# BUILDING PERMIT

Located At 963 WASHINGTON AVE

Job ID: 2011-05-1186-SIGN

has permission to replace existing 5'8" x 6'9" Sign for Port City Photography provided that the person or persons, firm or corporation accepting this permit shall comply with all of the provisions of the Statues of Maine and of the Ordinances of the City of Portland regulating the construction, maintenance and use of the buildings and structures, and of the application on file in the department.

# EXISTING SINAGE

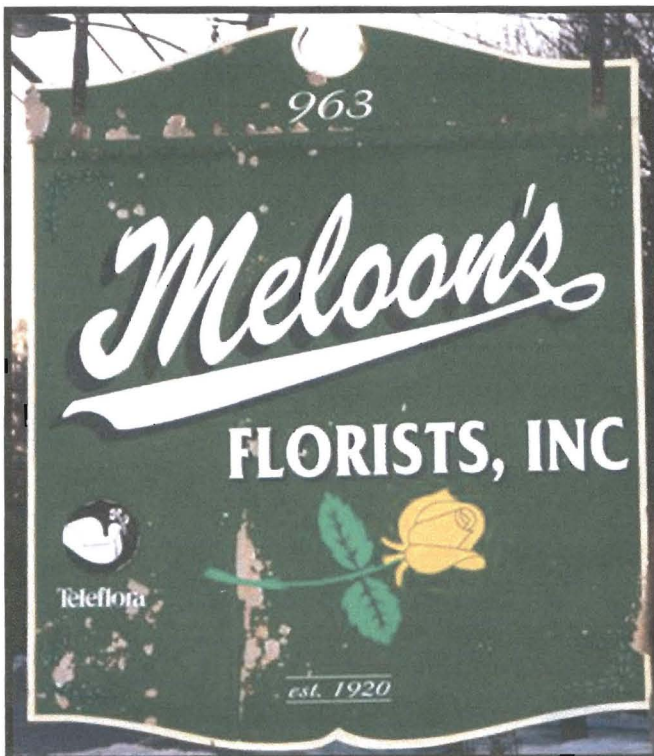
1. This permit is being issued to replace the existing 5'8" x 6'9.5" sign only. The 4' x 6' letter board was never permitted, and since this is a nonconforming use, there can be no increase in the square footage of the sign. The 4' x 6' letter board must be removed.
